**PACIFIC HIGHWAY (H10) - SSI 9837: NEWCASTLE POWER STATION PROJECT, LOT: 2 & 3  
DP: 1023561, 1940 PACIFIC HIGHWAY TOMAGO**

TfNSW have reviewed the Environmental Impact Statement (EIS) Amended Report prepared by AGL, dated August 2020, and relevant Appendices.

**Figure 5 | Project Site Layout – As Amended** (Source: Further information provided by AGL)

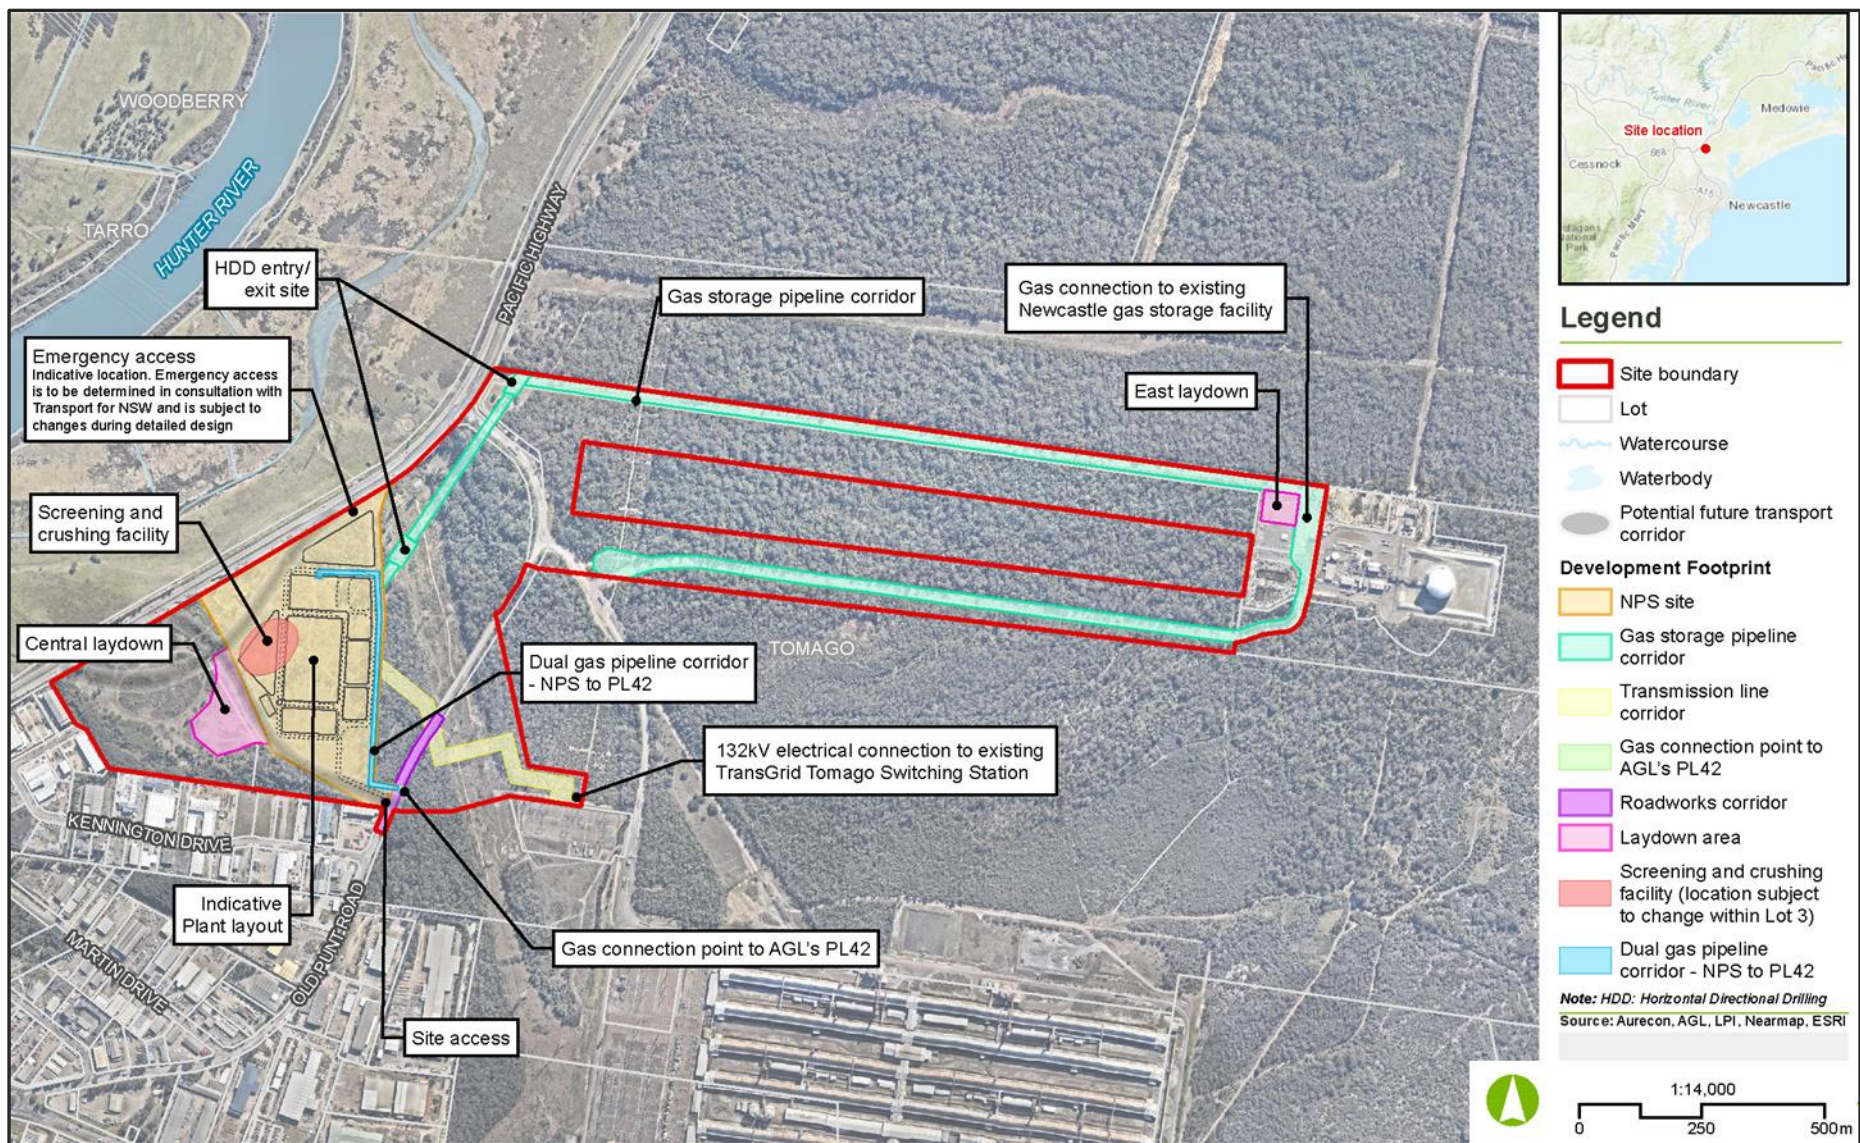
1. Gas Utility crossing at Old Punt Road near Pacific Highway

- a. AGL provided some information separately to TfNSW on where they are proposing to align the gas main but have failed to provide any further information on depth to utility, provide any further adequate commitment to what they are constructing and how they might protect it.
- b. Still outstanding.

- a. TfNSW previously made a comment that the lines should be no lower than the existing Transgrid power over Old Punt Rd due to the requirements for OSM vehicles. This has essentially been ignored.
- b. Still outstanding.
